CITY OF PORTLAND

Located At 34 MOODY ST

Job ID: 2012-07-4379-NEWCOM

DATE: 07.30.2012
TO/COMPANY: Jeanie Bourke
CEO/LPI/Plan Reviewer
City of Portland
Planning & Urban Development Dept. / Inspections Division
PROJECT: Adams School Condominiums
FROM: Kathy Cogan Kahill
PAGES:
RE: Code Review of BP# 2012-07-4379

A4 1ST FLOOR - CODE PLAN
1/16" = 1'-0"

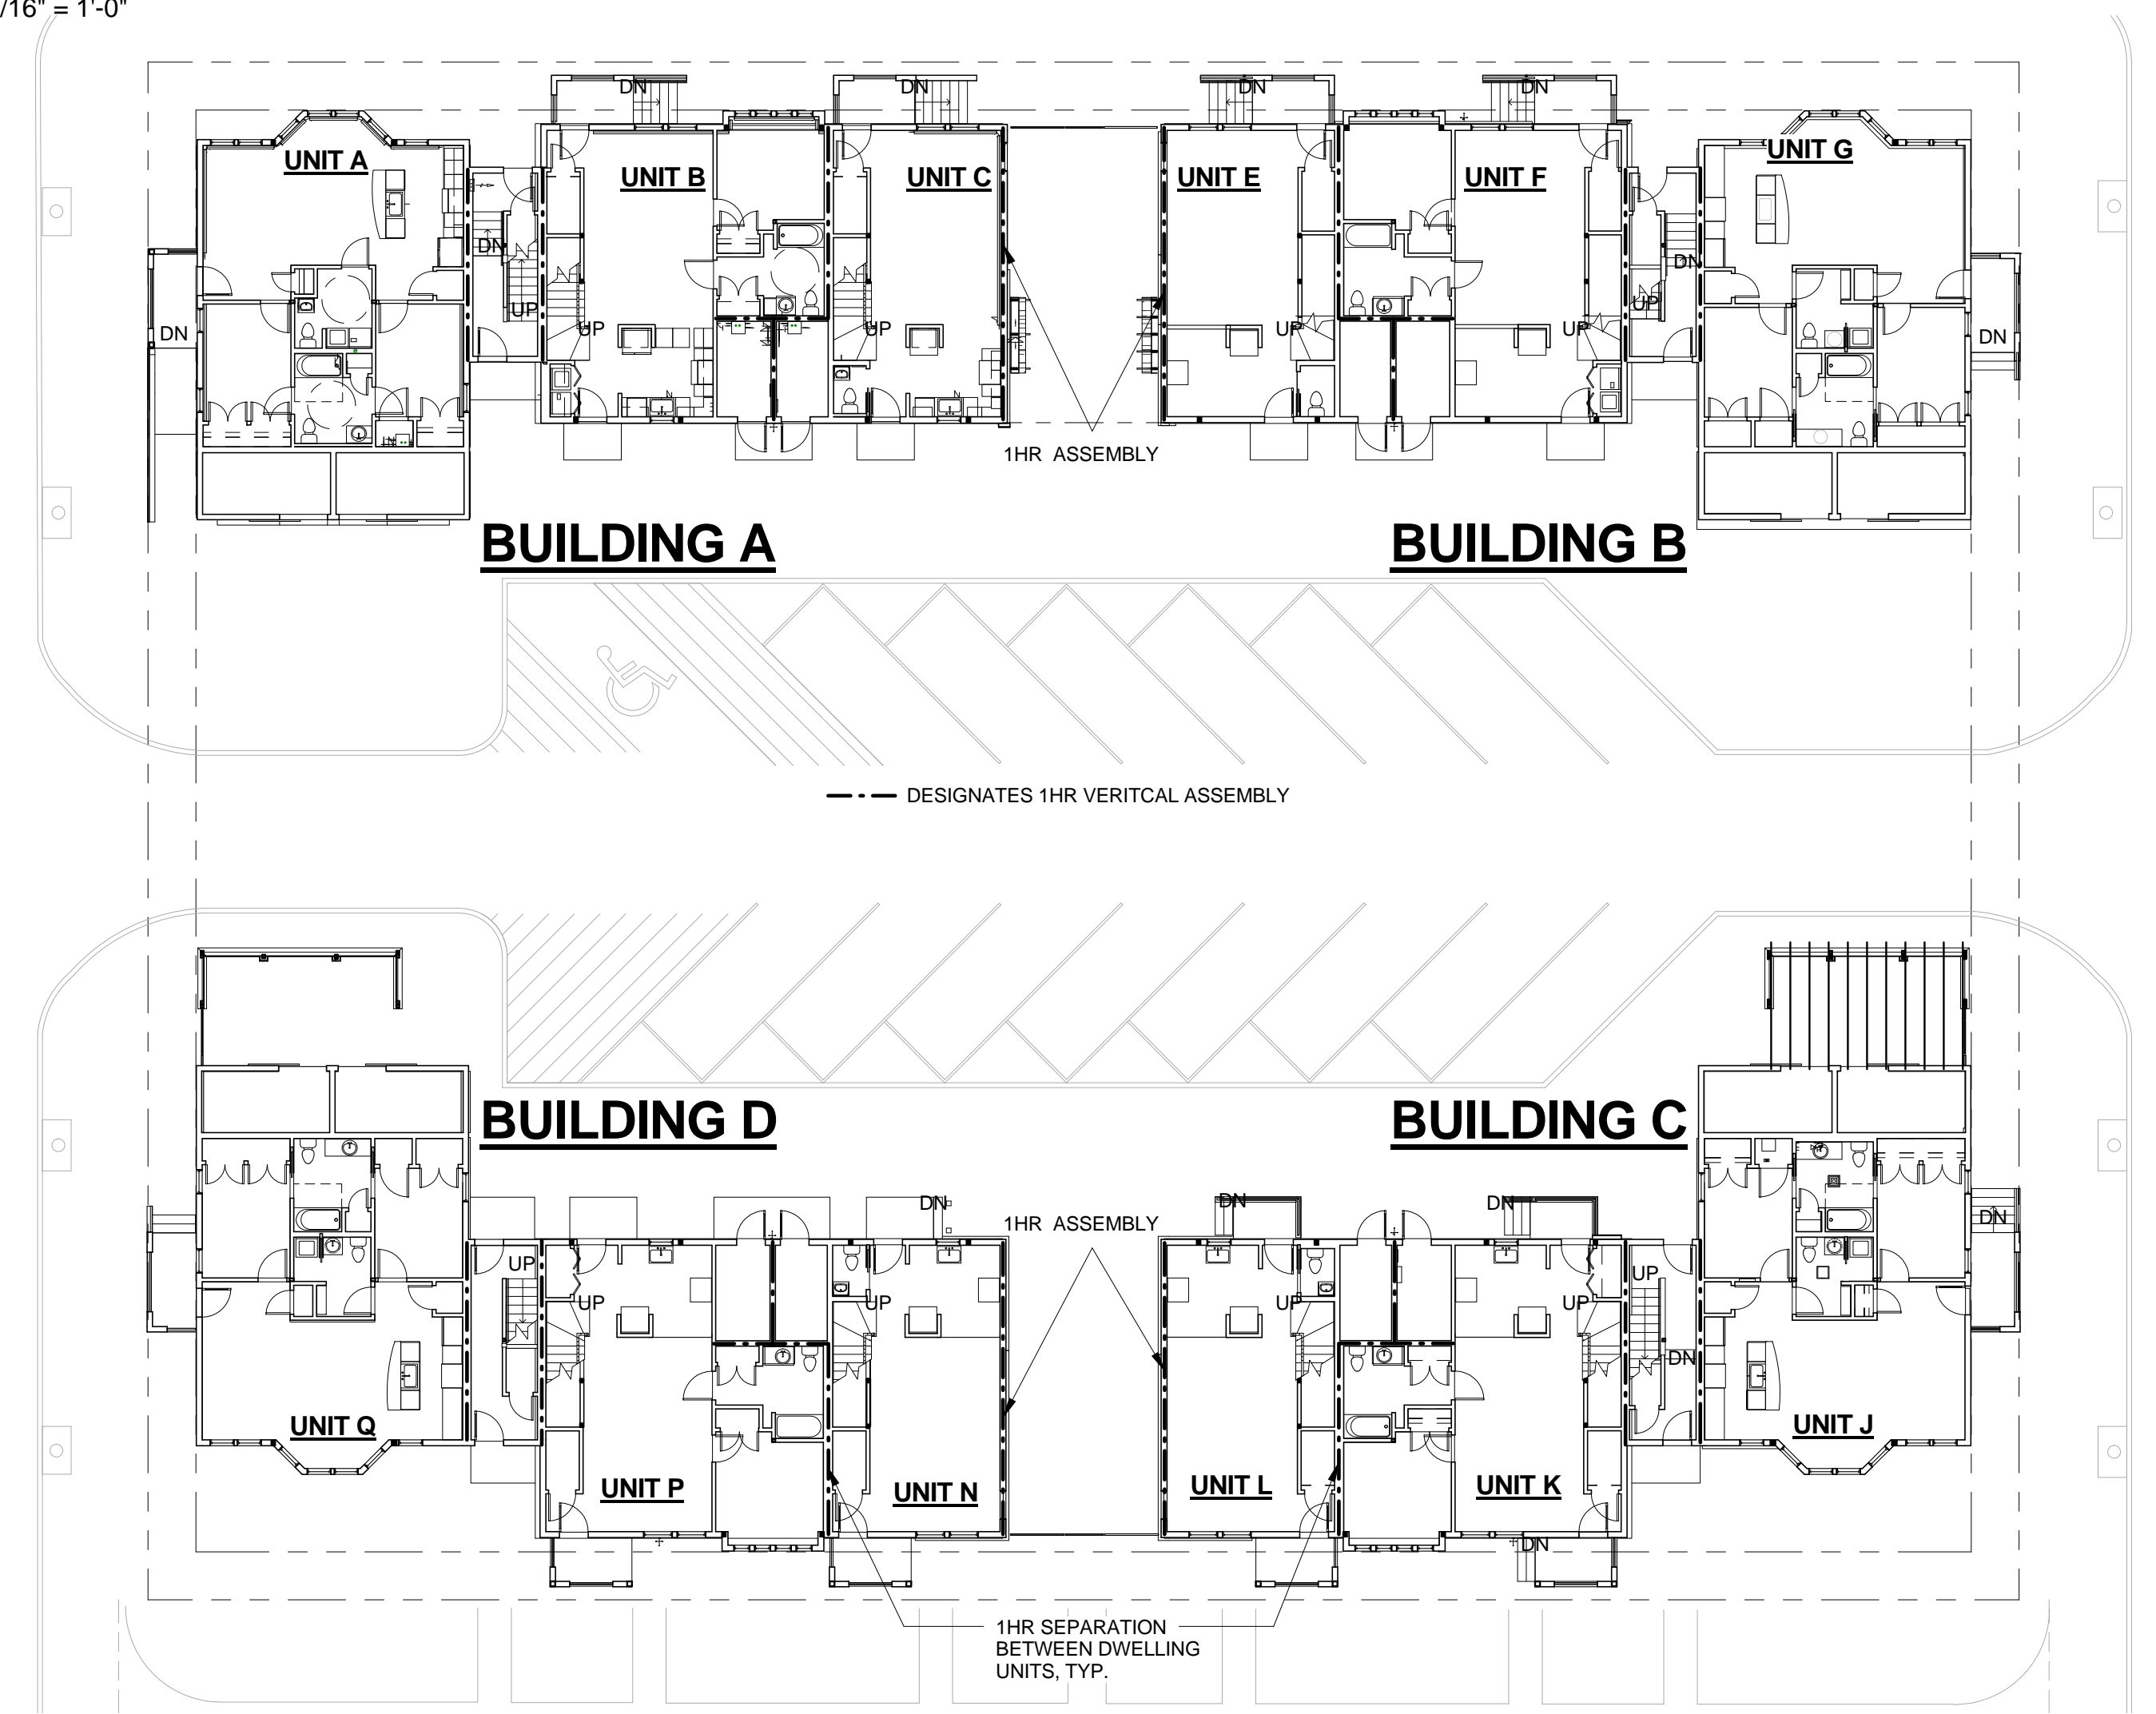
4. A-002, clarify the spec for 5/8" GWB as opposed to 5/8" Type X for rated assemblies.
Specification Section 092900 clarifies the use and installation of Type X GWB.
5. A-100, 1 hour separation at exterior walls, provide code justification for Sec. 705.8 Openings, Sec. 705.8.6 Vertical Exposure and Sec. 705.11 Parapets
Fire separation distances at rated exterior walls is 8 feet.
Allowable unsprinklered, unprotected openings is 10% Per IBC 2009 Table 705.8
Actual openings are 70 SF/779 SF total area = 9% due to NFPA BIR

6. A-103 / A-104, clarify the rated exterior wall C12 is only rated at the first floor wall. Wall C12 shall be full height extending to the underside of the roof as tagged on A-104 and indicated as 1HR rated with a dashed line on A-100, A-101, and A-102. Clarification will be issued to general contractor.

7. A-105 / A-106, clarify the bldg. C exterior wall C-1 is specified at the adjacent bldg. D wall. Exterior walls at both C and D buildings that are adjacent to each other shall be wall type C-12, 1 hour rating similar to buildings A and B as indicated with dashed line on sheets A-100, A-101, and A-102.

Openings are separated by a minimum of 3'-0" in compliance with IBC 2009 Section 705.8.5. No openings occur 15'-0" above the roof of adjacent buildings on the same lot, and therefore are not governed by IBC 2009 Section 705.8.6

Per IBC 2009 Section 705.11 Exception 1 a parapet is not required where exterior walls are not

required to be fire-resistance rated because of fire separation distance.

At exterior walls required to be 1hr rated, no parapet is required where the roof framing elements parallel to the walls and supporting structures are of 1 hr fire rated construction for a width of 4 feet.

Note: roof has a Class A roof covering and roof structure shall be 1-hr for a width of 4 feet. Clarification will be issued to the contractor.

In light of this, a rated exterior wall is not required between buildings A & B and between buildings C & D; subsequent roof and roof structure ratings are also not required.
